From: Michael Eastham <Michael.Eastham@arun.gov.uk>
Sent: 07 August 2020 13:00
To: Planning.Responses <Planning.Responses@arun.gov.uk>
Subject: FW: 22995 - Manor Nursery A/86/20/DOC - Designer Response

Subject: 22995 - Manor Nursery A/86/20/DOC - Designer Response

Condition 21- surface water drainage design

TITLE
Proposed Drainage Strategy

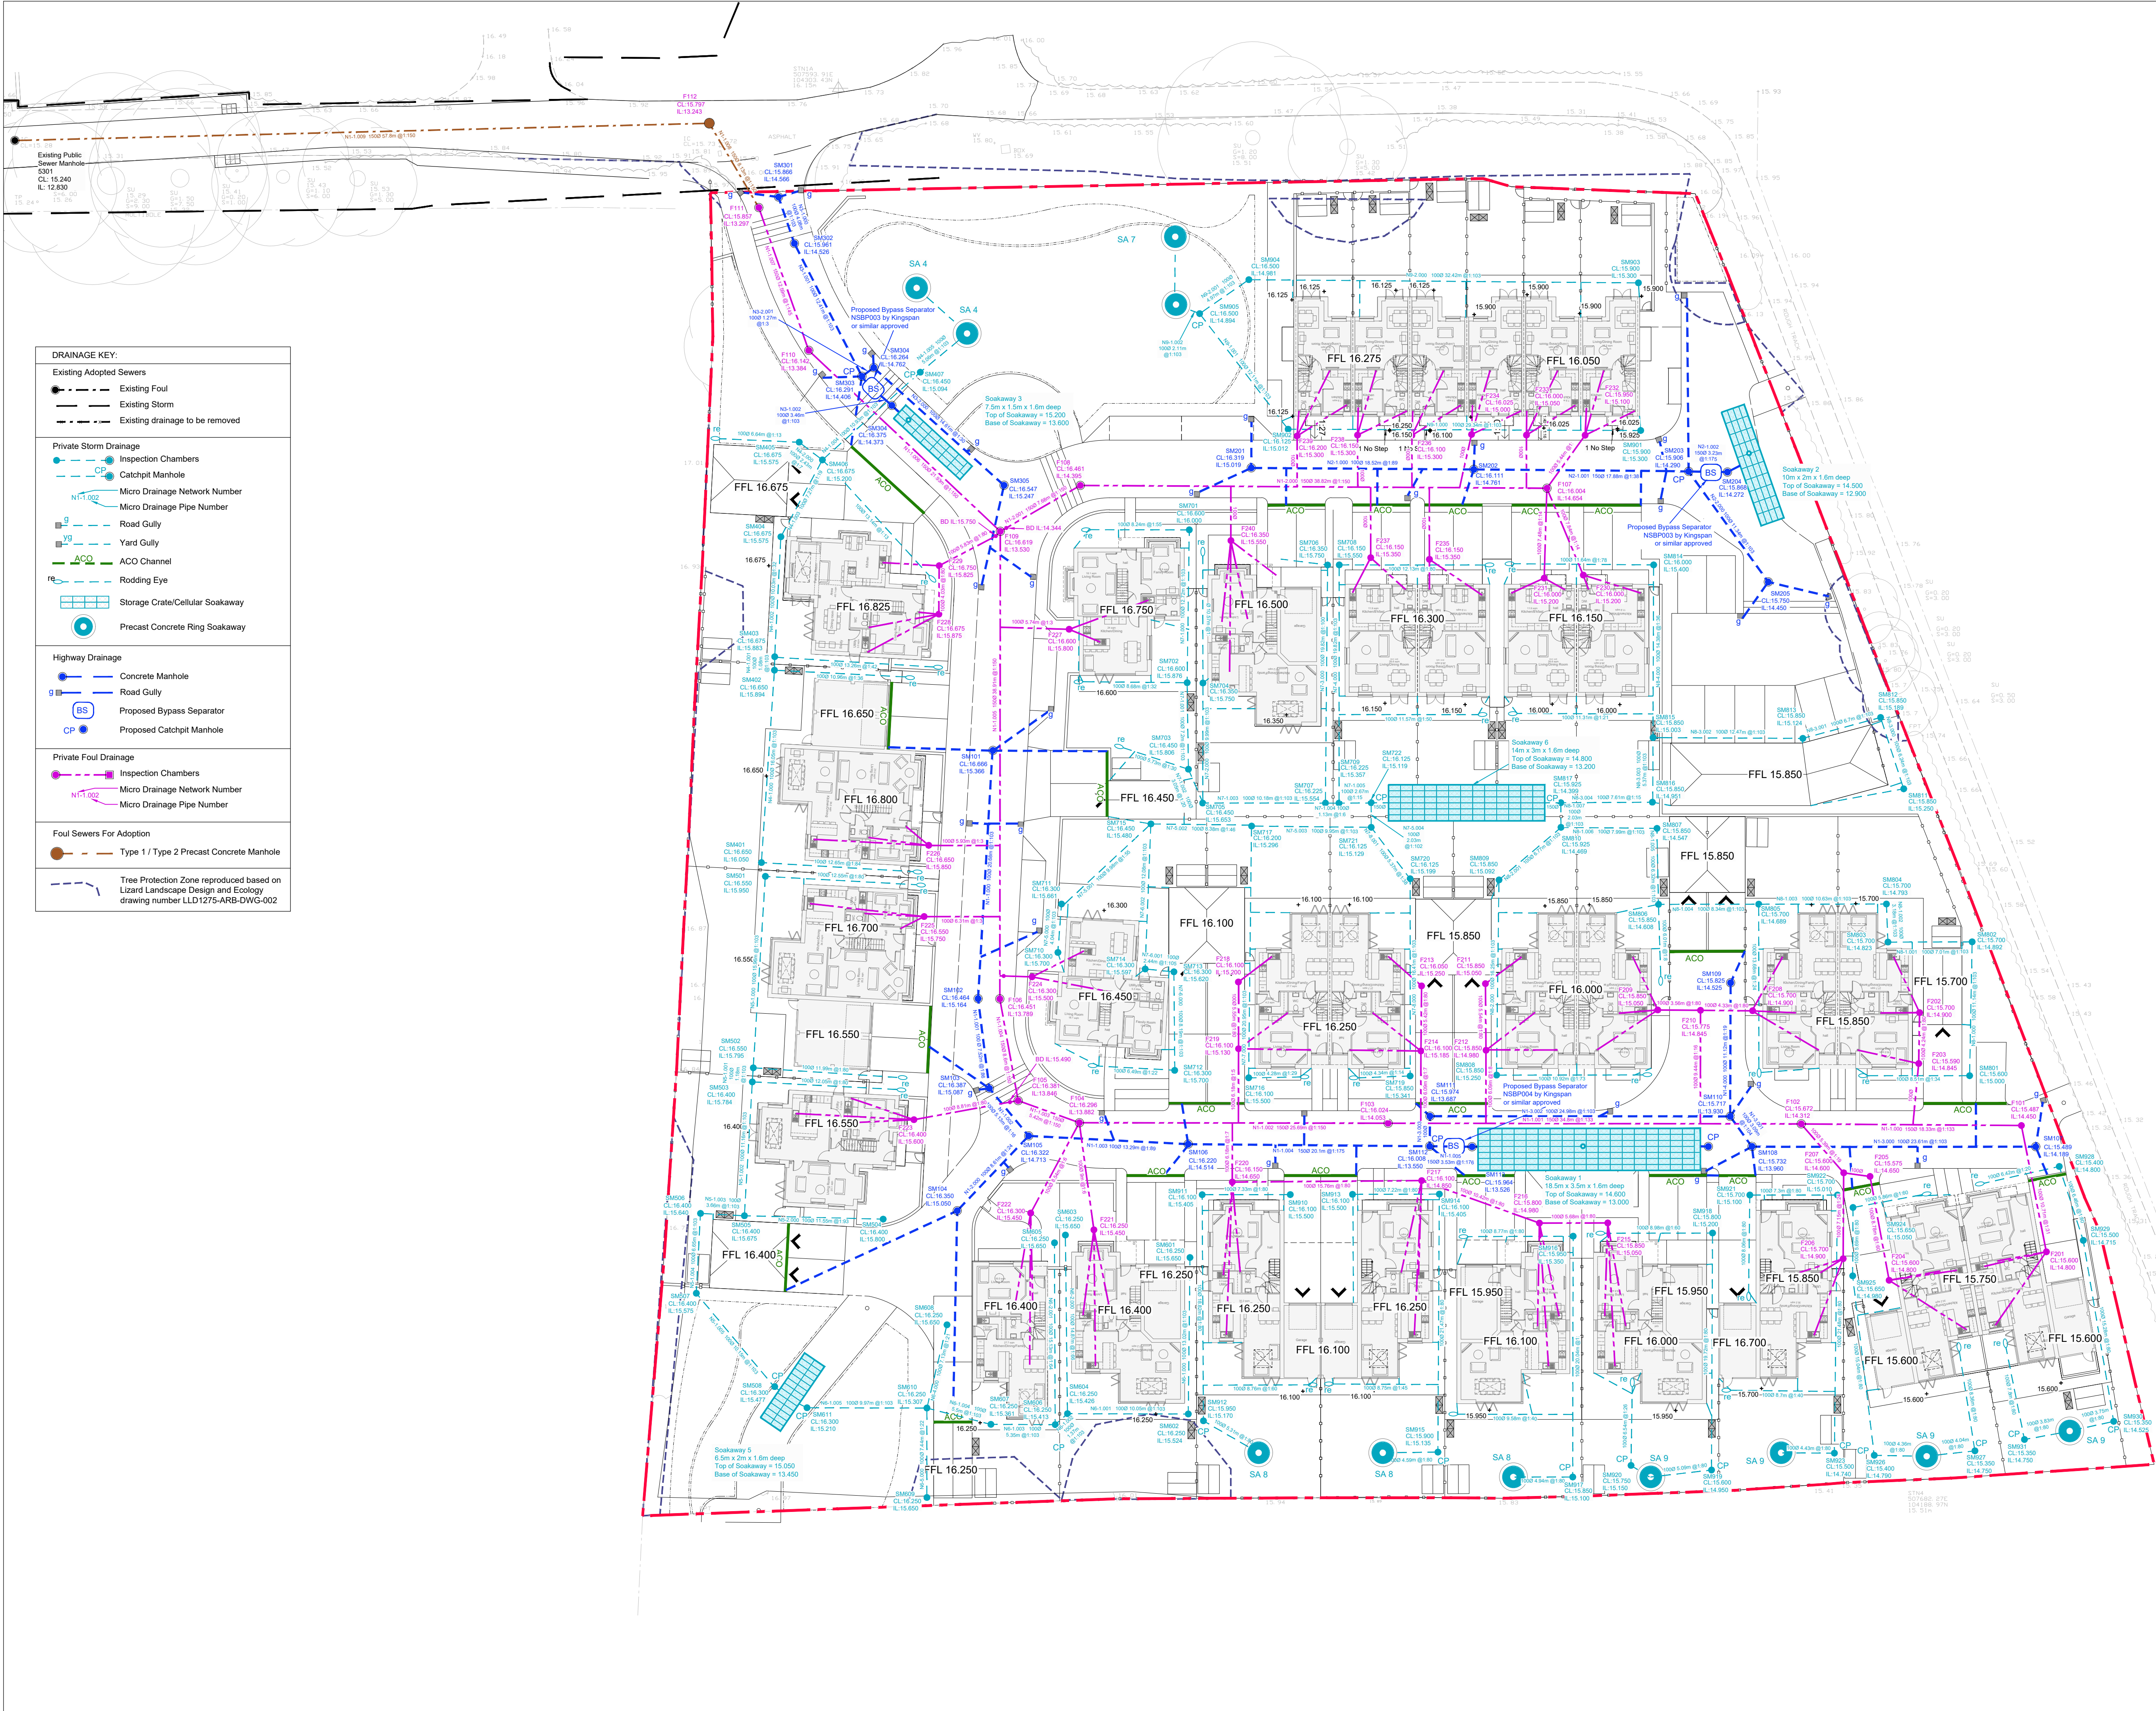
3. All infiltration tests were undertaken at circa 2.5m depth, yet some of the soakaways are considerably shallower than this.

The design notes only two soakaway designs with the base shallower than 2.5m blg. These are SA8 and SA9 and both are located within the gardens of the properties along the southern boundary of the site. Soakage testing was undertaken at a depth of 2.5m within the gravel strata below the site. The trial pit logs within this area, TP1, TP2 and TP3, confirm the gravel strata is located at between 2.1 and 2.2m below ground and extends to the base of the trial pits. SA8 and SA9 soakaways are situated within this gravel strata. We therefore request this objection is removed based on the designed soakaways' depth extending into the tested soil strata where they will have the same performance as the tests. We have attached the Trial Pit data and location plan.
